Alterations

28 Ferring Street Ferring

Ferring Conservation Group objects to this application on the grounds that its proposals for fascia and lighting do not acknowledge that the premises are immediately adjacent to the very small Ferring Conservation Area.]

DRW NO 6b SCALE 1/50 (A3)
PROPOSED FRONT ELEVATION

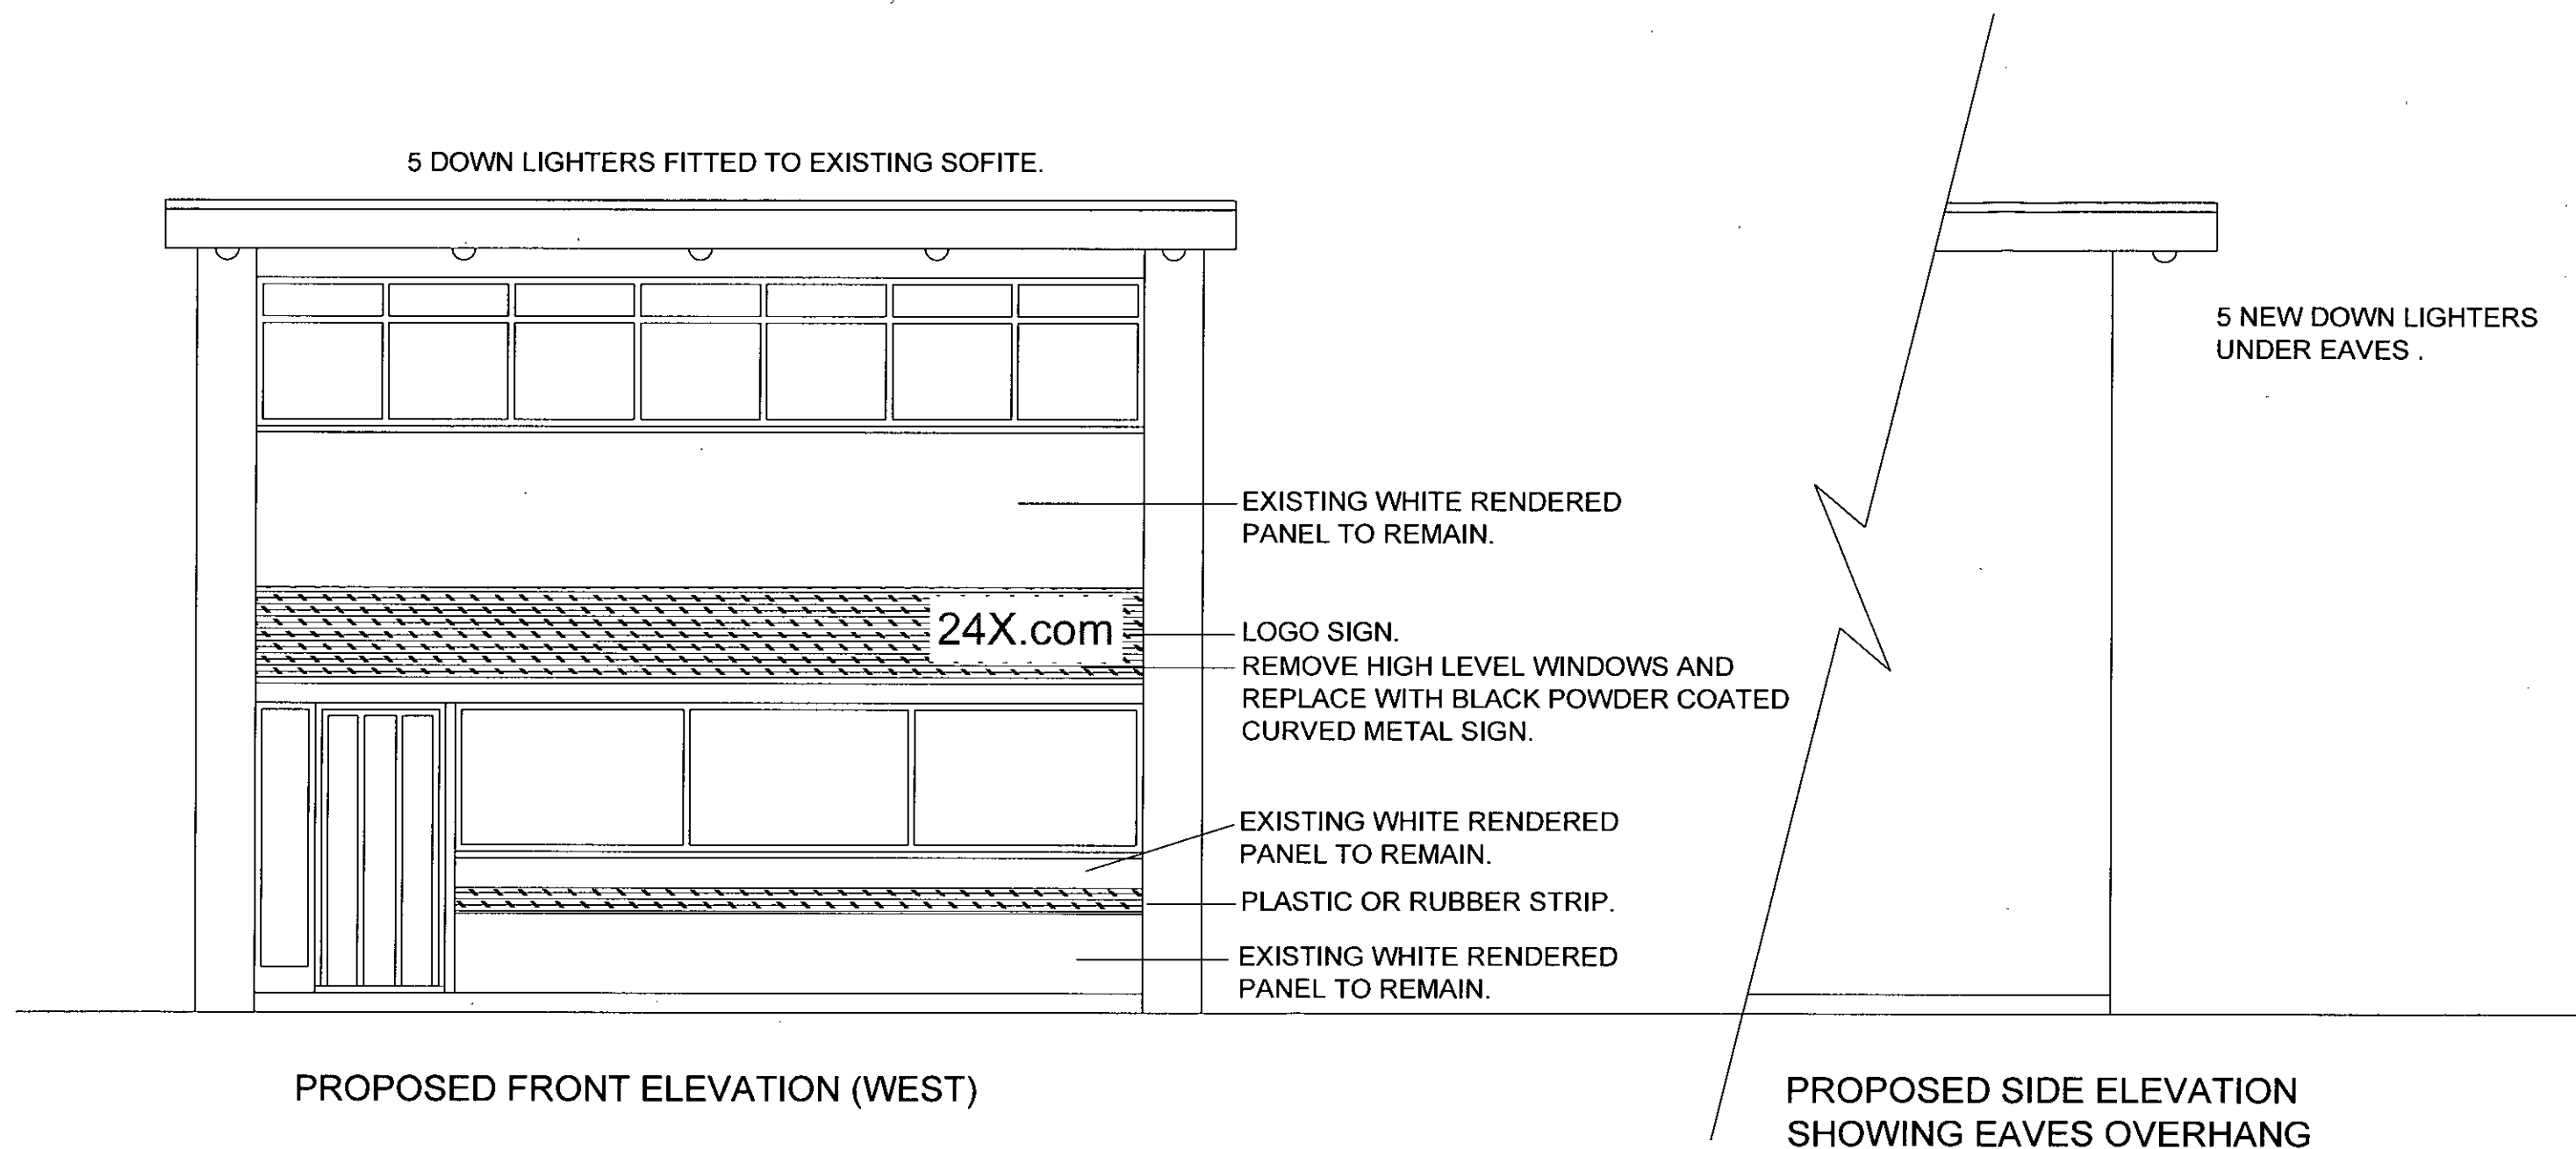
It is not possible to judge from the diagram of the west elevation what the fascia will look like or where the lighting will be placed. Nor is there any indication as to what times the illumination is intended to operate. 'Brushed alloy' may possibly be appropriate but it may be rather garish and 'in your face'. We would want to see the fascia and its illumination to be discreet and in keeping with the character of the Conservation Area (and, indeed with the character of an Undertaker's premises.)
